From: Amanda Scholes on behalf of Planning.Responses
Sent: 10 March 2021 10:01
To: Planning Scanning
Subject: FW: Planning Consultation on: Y/15/21/DOC

Thank you for consulting us on this discharge of conditions application. We have the following comments.

Condition 9- surface water drainage strategy

Description of Works: Approval of details reserved by condition imposed under ref Y/88/18/OUT relating to Condition No 8 - drainage strategy, 9 - surface water drainage, 10 - maintenance & management of surface water drainage and 11 - broadband.

Drawing Title
**DRAINAGE CONSTRUCTION
DETAILS (SHEET 2 OF 2)**

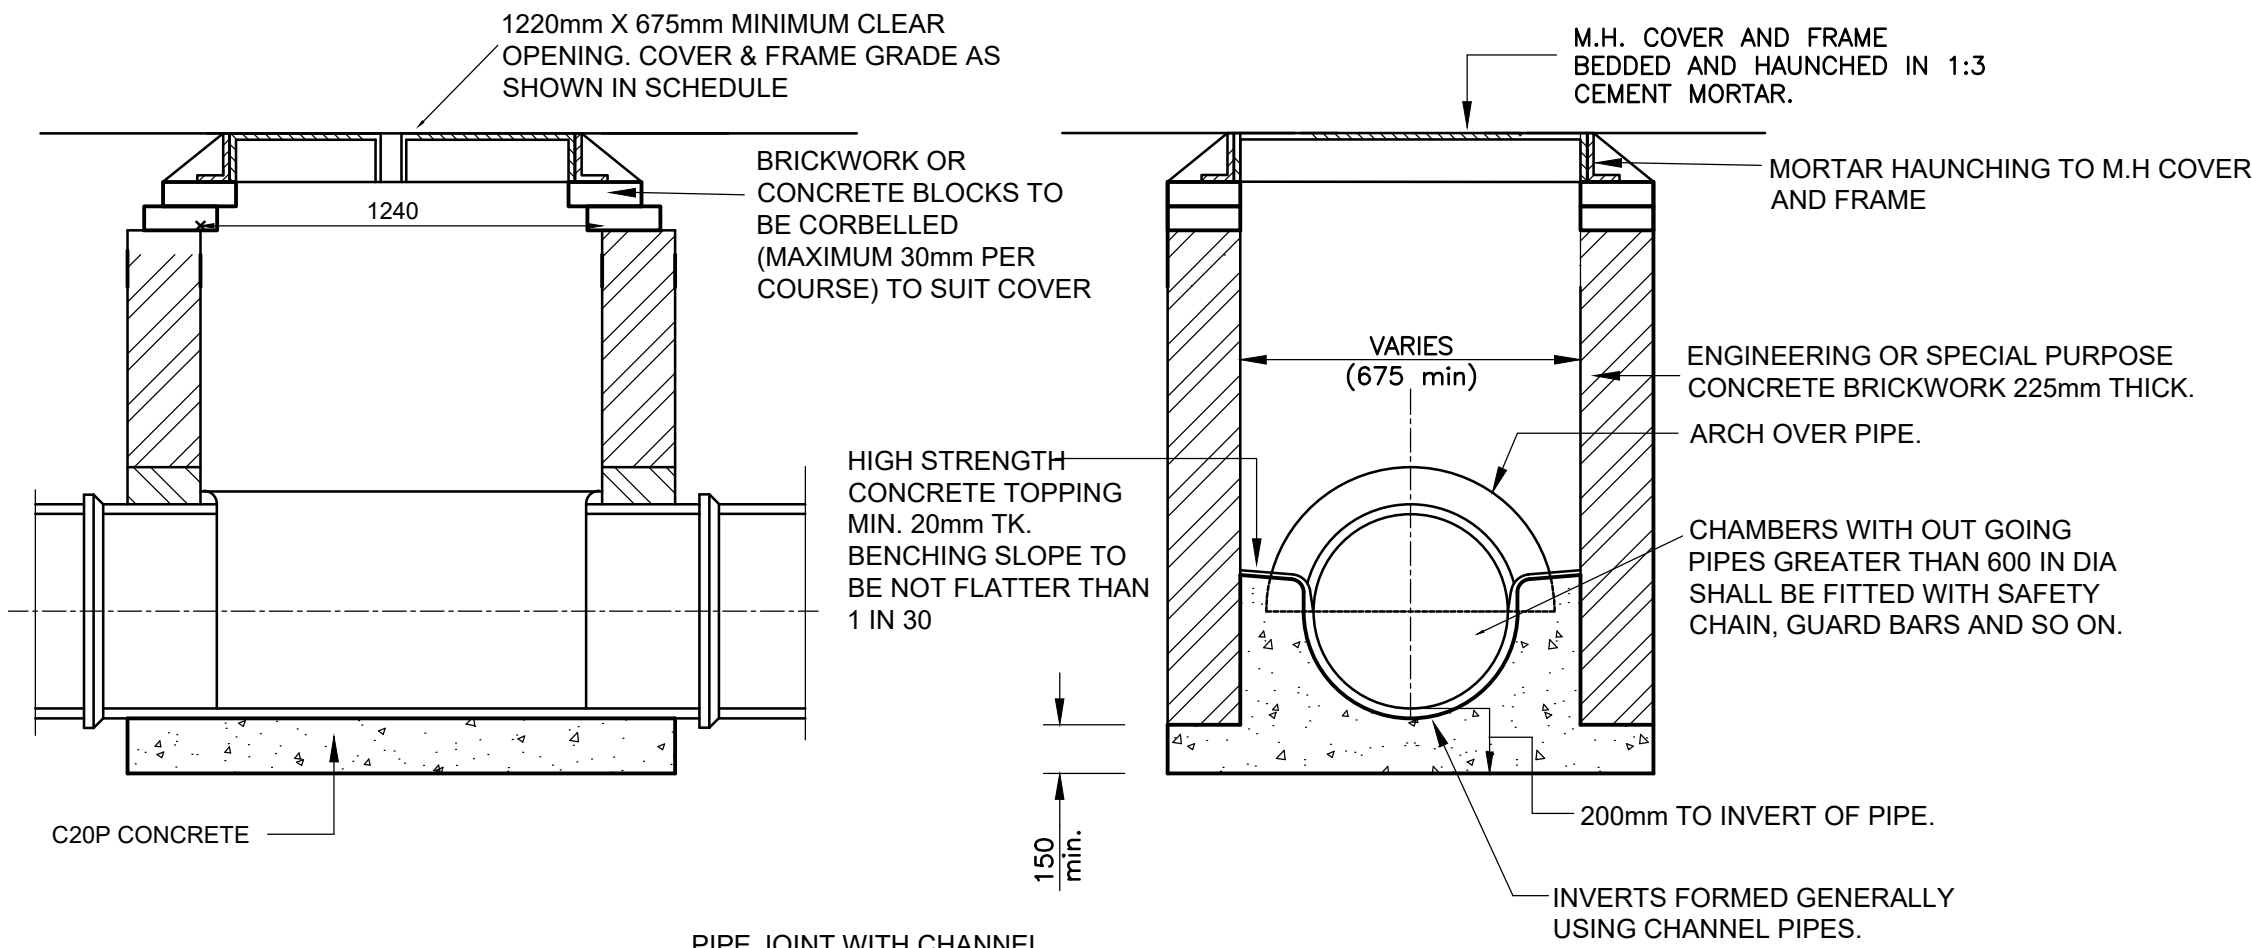
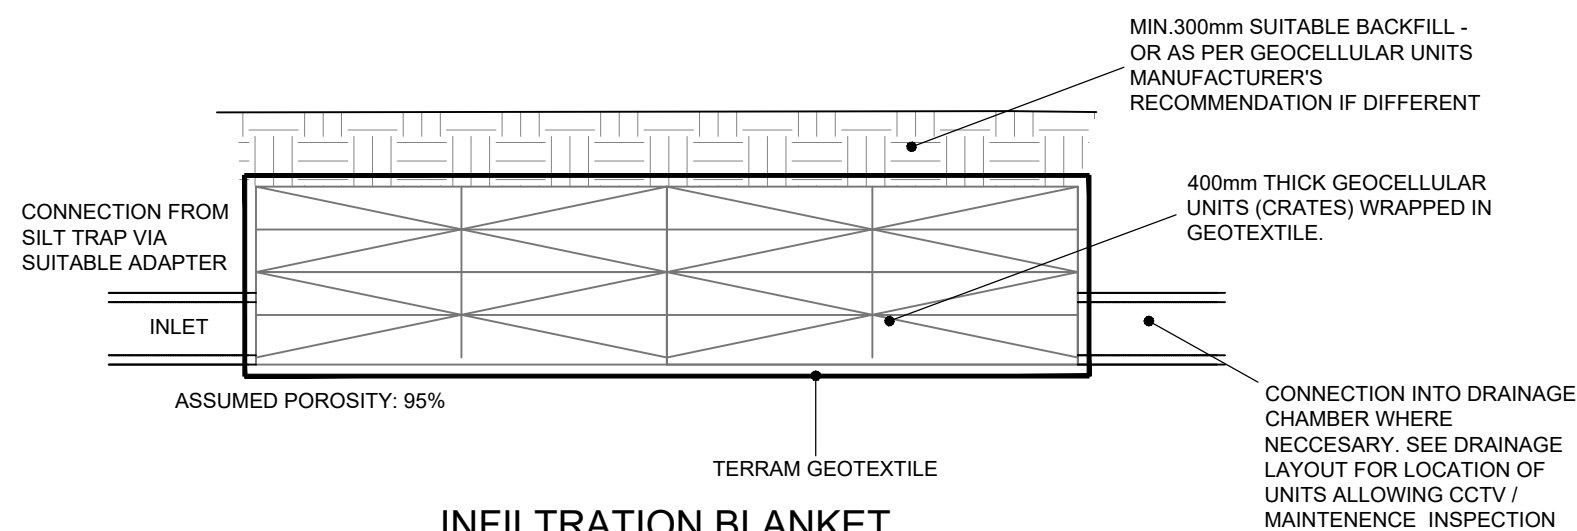
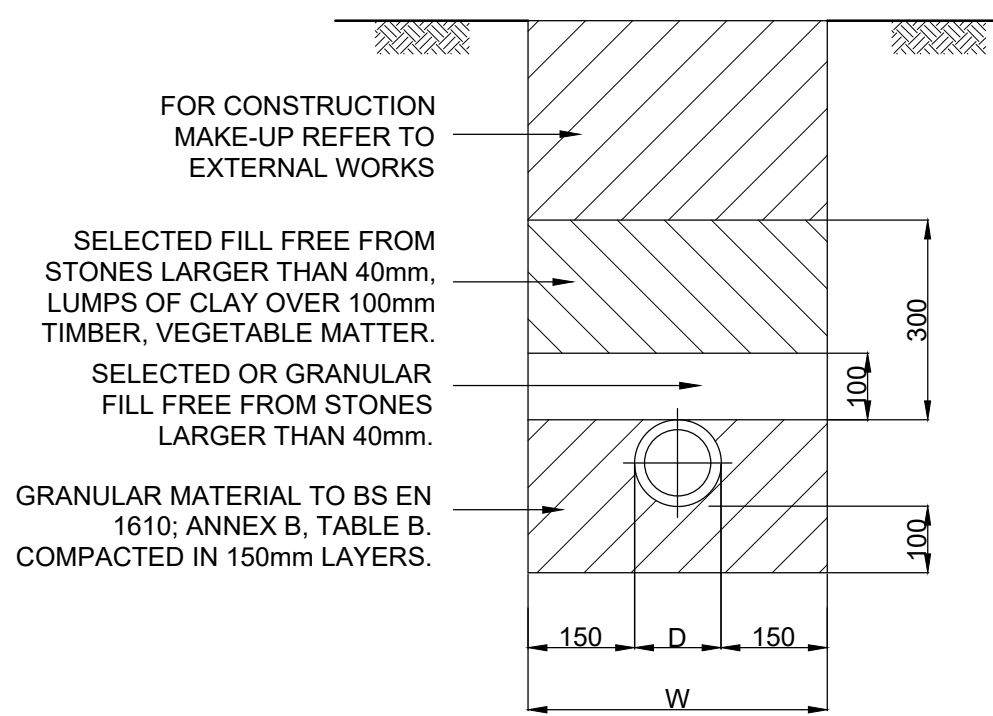
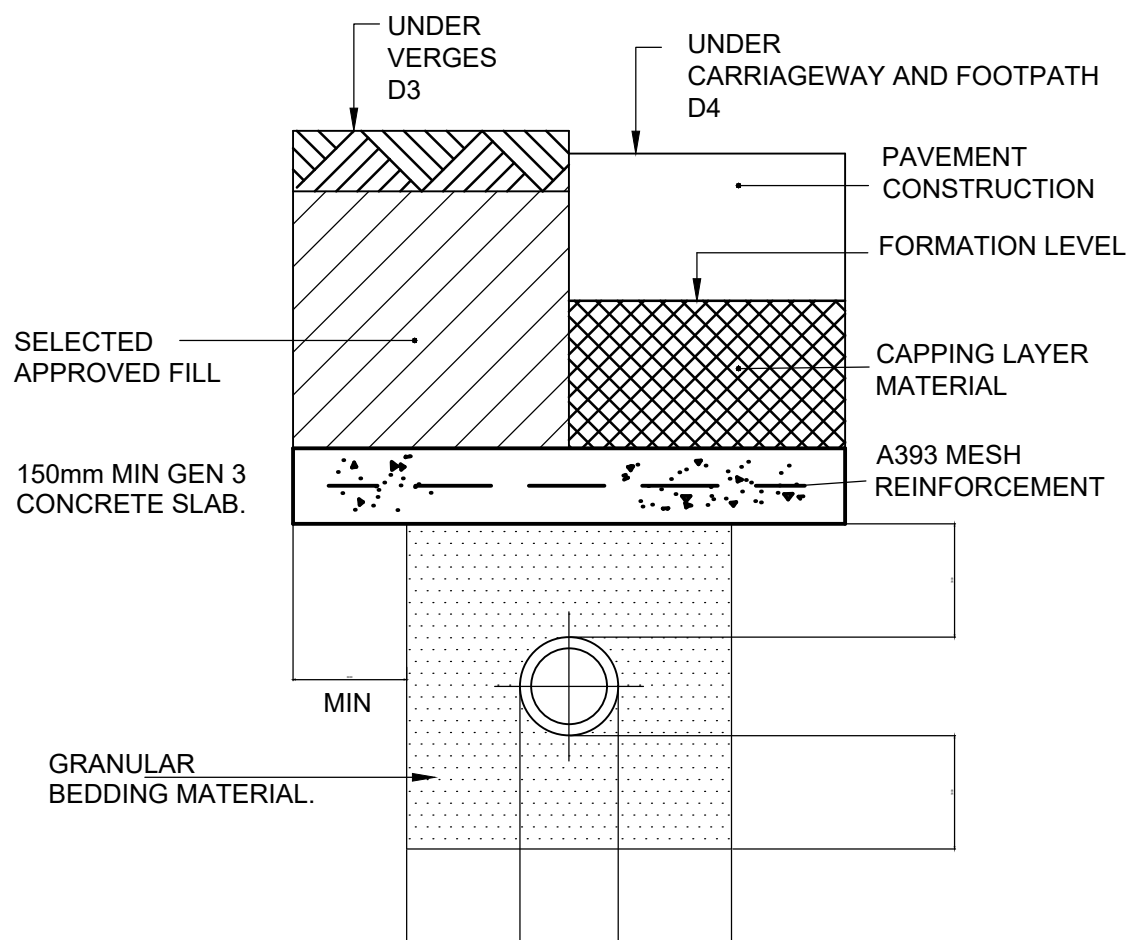
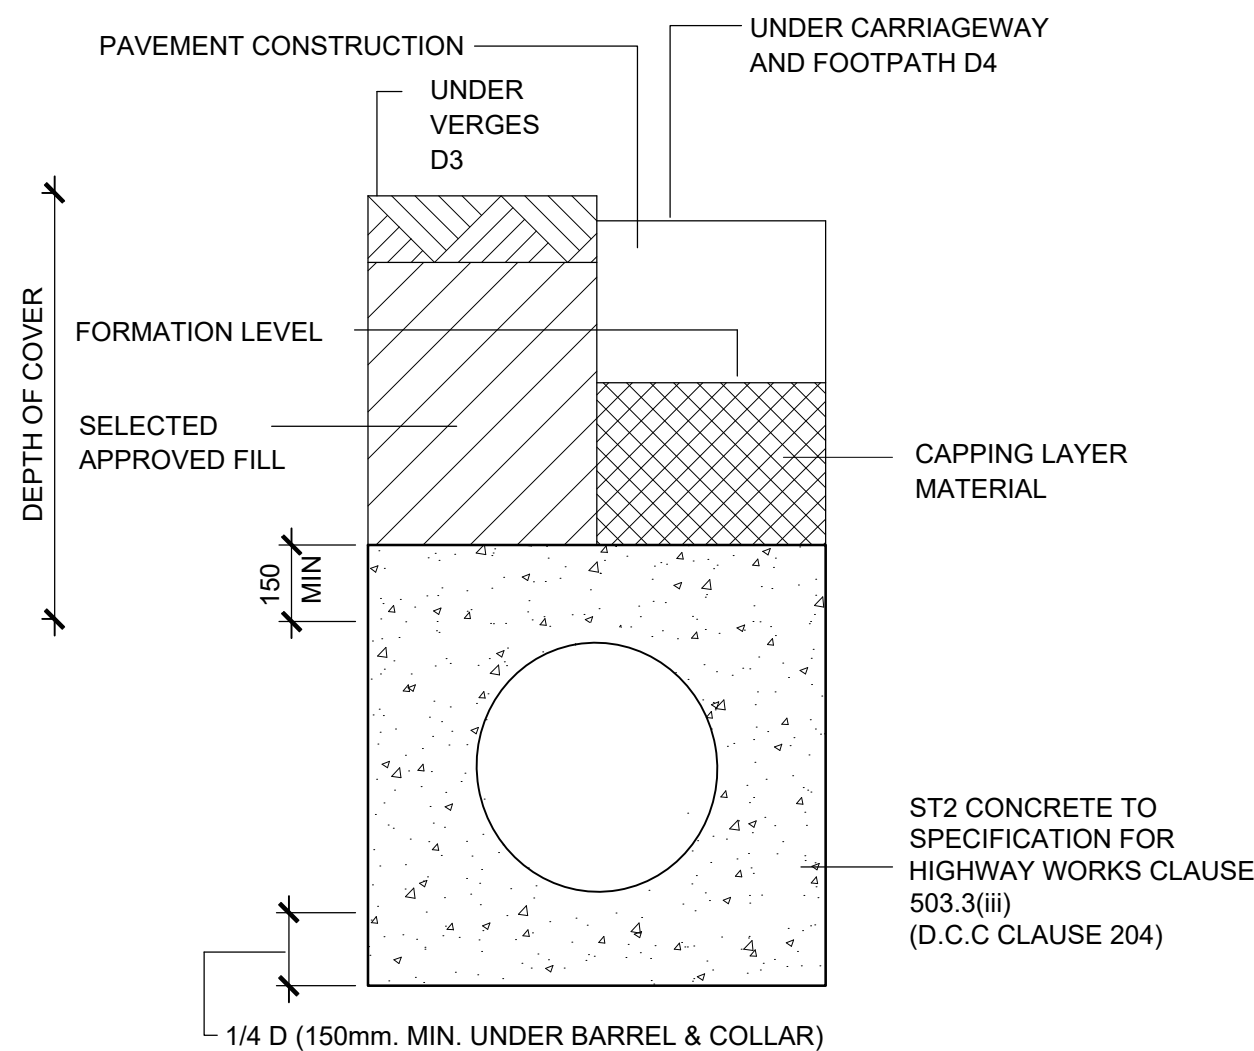
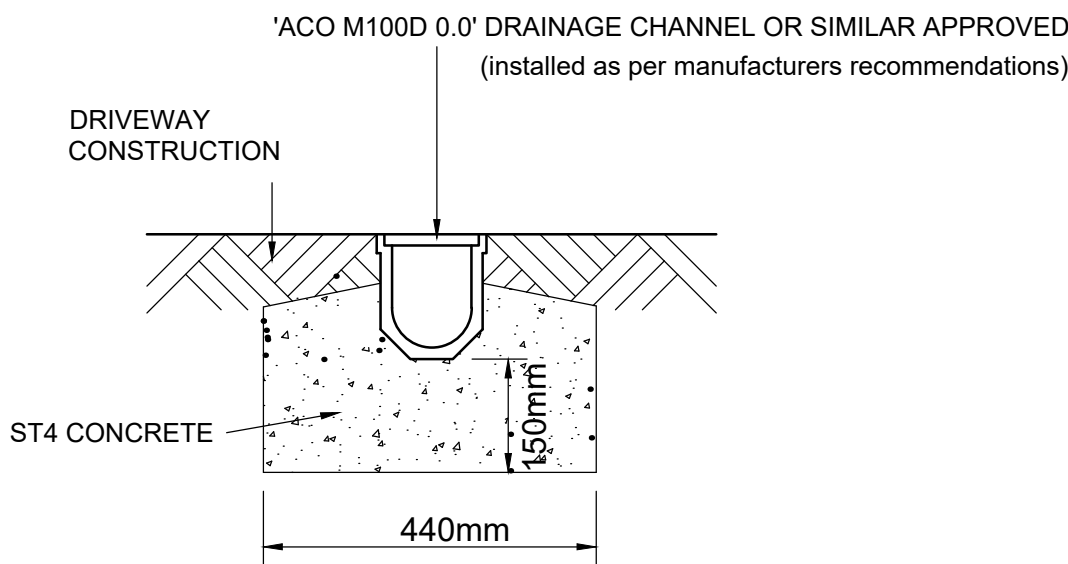
6. Please specify sand bedding and surround to infiltration blankets. Bedding layer specification provided on drawing YAP-180-031C2. *Okay, point closed.*

7. Please identify on construction details of infiltration blankets that invert level is to be as per drainage layout drawings. Currently you are showing incoming pipes at the base of crates. Infiltration blanket detail adjusted as requested. Please see drawing YAP-180-031C2. *Okay, point closed.*

8. Please remove irrelevant construction detail drawings, e.g. hybrid infiltration blankets, infiltration blankets with overlying infiltration basins, and gully grating within infiltration basin. Construction detail drawing updated - please see drawing YAP-180-031C2. *Okay, point closed.*

13. Please provide a construction detail which shows connections into permavoid crates. Construction detail drawing updated - please see drawing YAP-180-031C2. *Okay, point closed.*

Job Title			
LAND AT STAKERS FARM, YAPTON			
Drawing Title			
HIGHWAY CONSTRUCTION DETAILS (SHEET 1 OF 2)			
Client			
DANDARA LIMITED (SOUTHERN)			
Scale	Date	Designed	
AS SHOWN @A1	SEP 2020	AK	
Drawn	Checked	Approved	
JK	AK	SW	
Job No	Drawing No	Rev	
19-156	YAP-180-035	T4

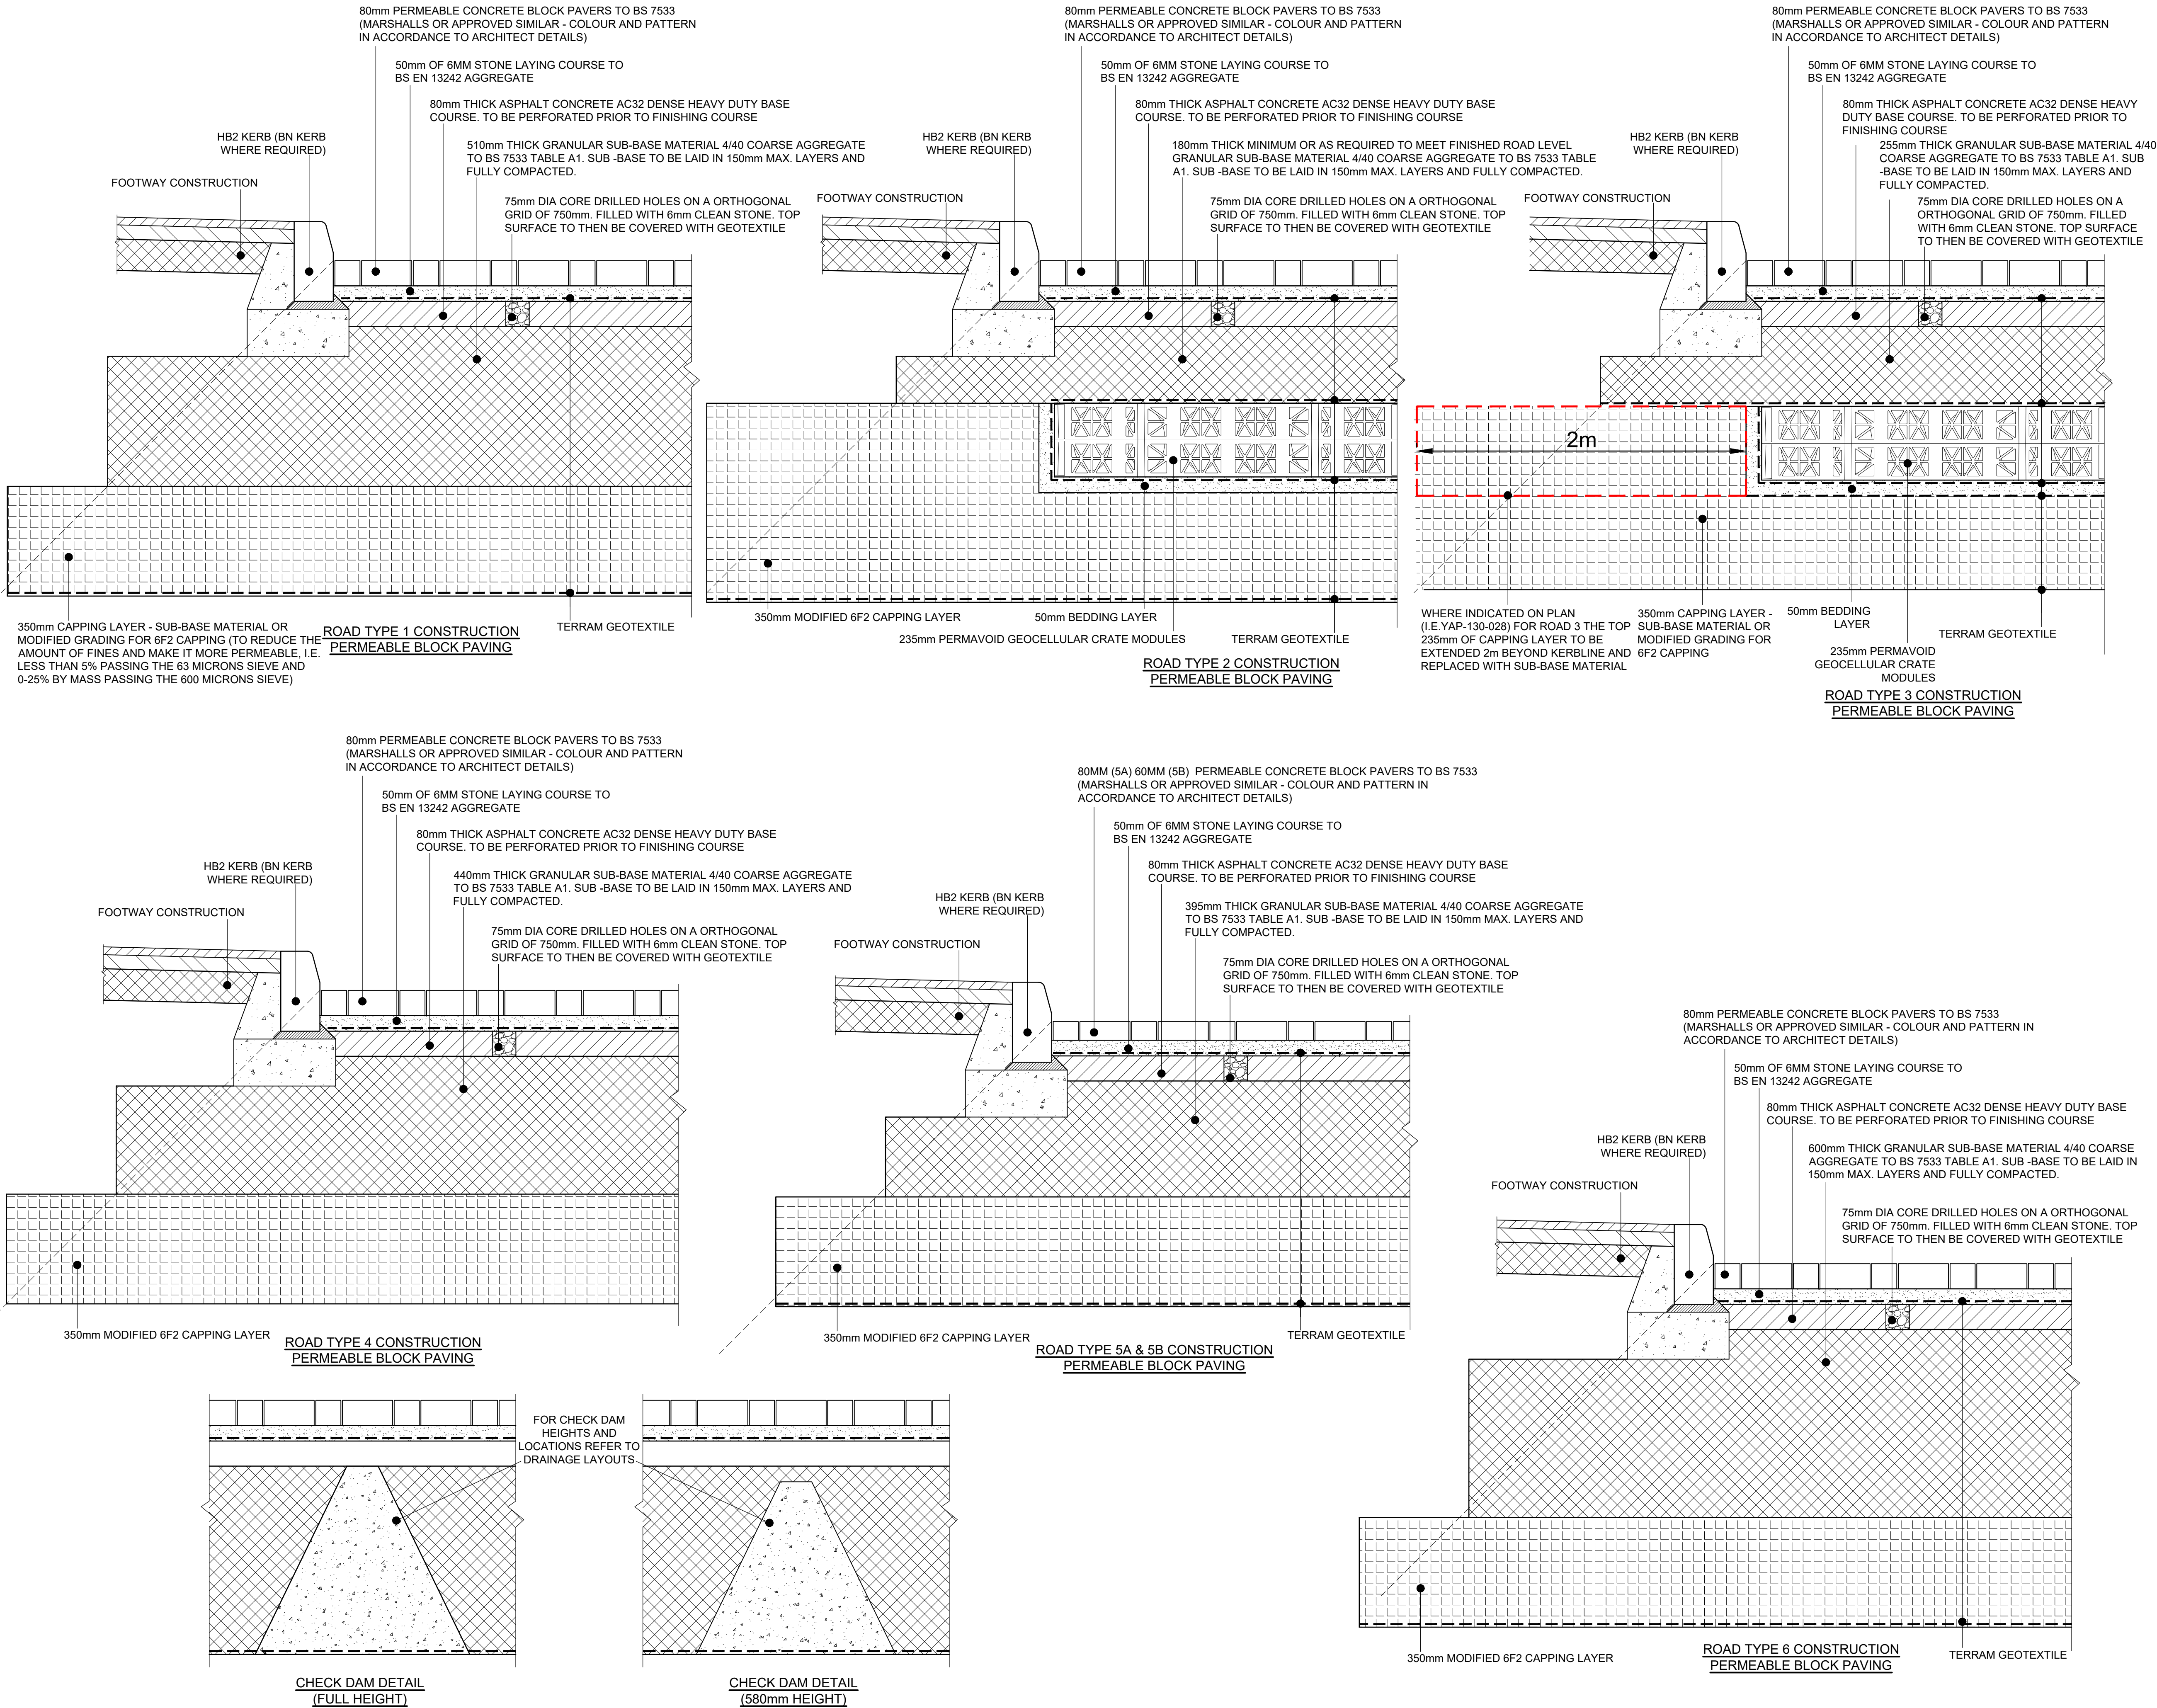
9. The construction detail drawings for the permeable paving and highways show a capping layer below the sub-base. The capping layer specified is not appropriate as it contains a high degree of fines and will not be permeable. Please remove this capping layer or replace it with a suitable permeable material. Capping layer specification adjusted to match sub-base – please see drawing YAP-180-035C2. *Okay, point closed.*

10. Please specify the material for the bedding layer underneath and around the permavoid crates on the permeable paving construction details. Construction detail drawing updated - please see drawing YAP-180-035C2. *Okay, point closed.*
